City of Portland, Maine - Building or Use Permit Application

Permit No: 02-1072	Issue Date: OCT 29 2002	CHL: 284 E006001
-----------------------	----------------------------	---------------------

Location of Construction: 15 Kent St	Owner Name: Platts Roberta J Wid Vn Vet	Owner Address: 15 Kent St	Phone: 774-9026
Business Name:	Contractor Name: Starbird Construction	Contractor Address: Portland	Phone:
Lessee/Buyer's Name:	Phone:	Permit Type: Additions - Dwellings	Zone: R-3

Past Use: Garage	Proposed Use: 348 sq ft Detached Garage	Permit Fee: \$86.00	Cost of Work: \$9,000.00	CEO District: 3
Proposed Project Description: Construct New 348 Sq Ft One Car Detached Garage - rebuild from Demold Garage		FIRE DEPT: <input type="checkbox"/> Approved <input type="checkbox"/> Denied	INSPECTION: Use Group: <i>U</i> Type: <i>5B</i> <i>BOCA 1999</i>

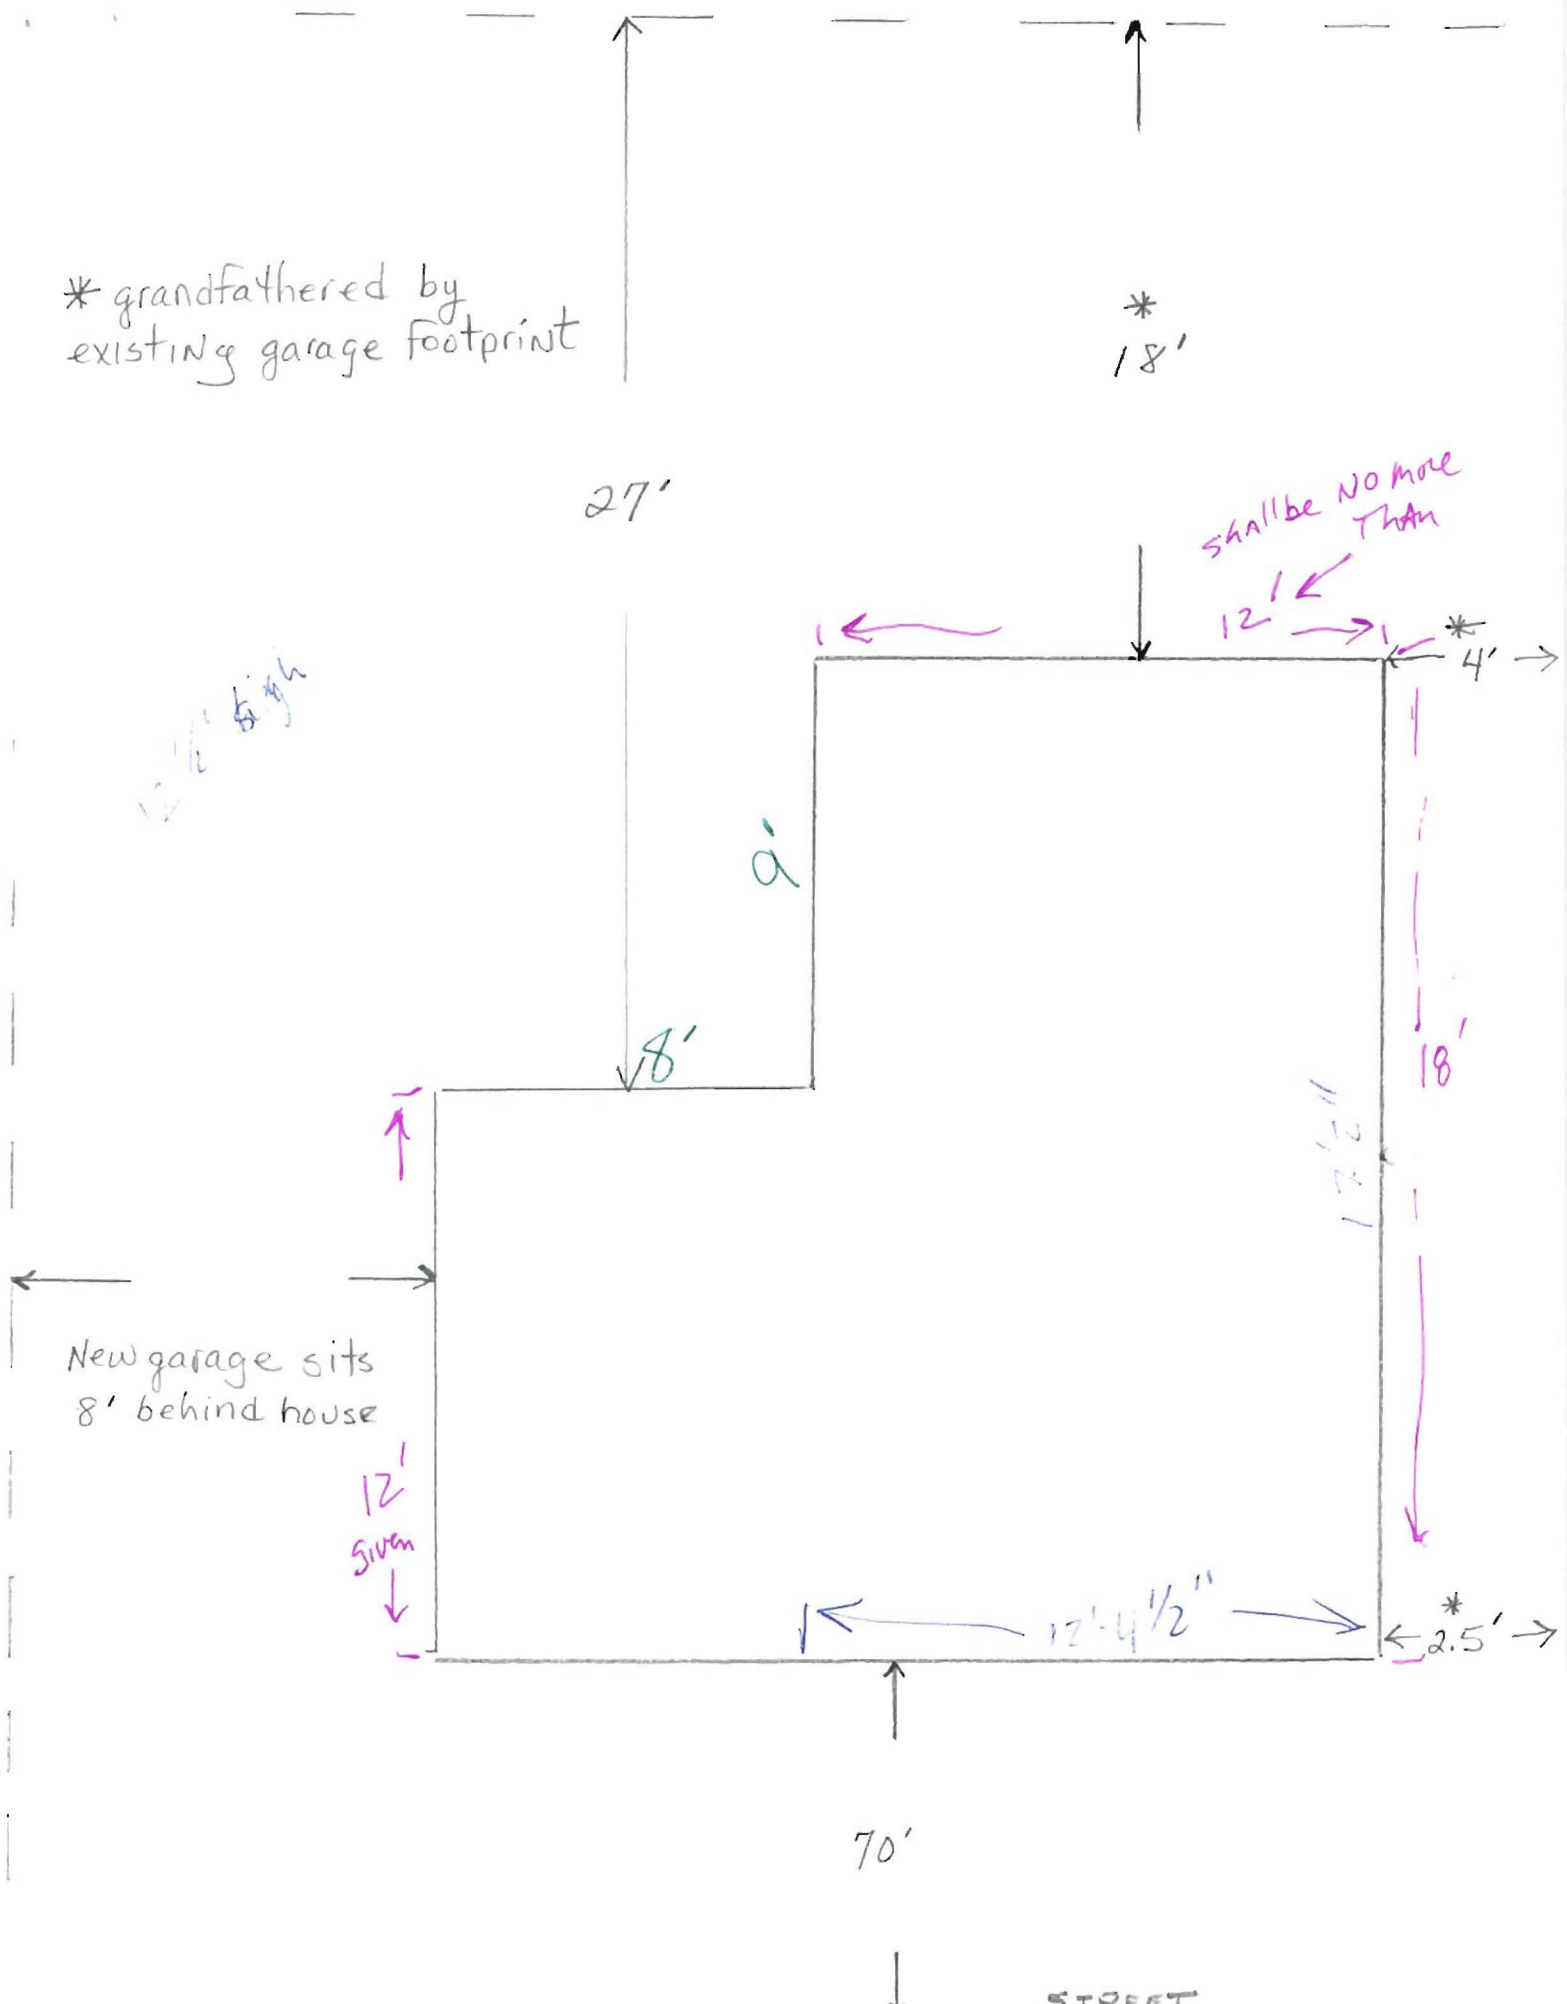
Your present garage structure is legally nonconforming as to setbacks. If you are to demolish this structure on your own volition, you will only have one (1) year to replace it in the same footprint (no expansions), with the same height, and same use. Any changes to any of the above shall require that this structure meet the current zoning standards.

It is understood that there is a rear "dog shed" addition on the rear of this garage. This may be used for the measurement of your garage. Please have the Code Enforcement Officer measure and document the existing garage PRIOR to demolition.

FOUNDATION

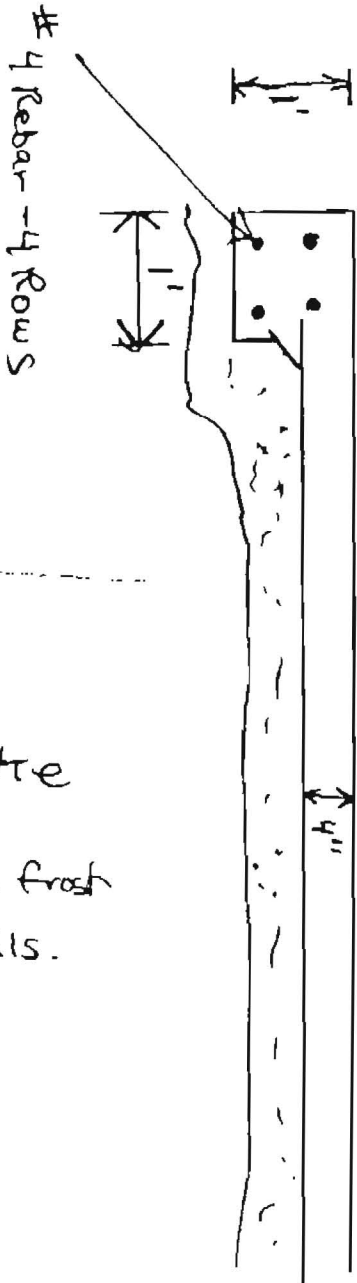
Frost protection of slab to be provided as per the specs on the enclosed descriptions
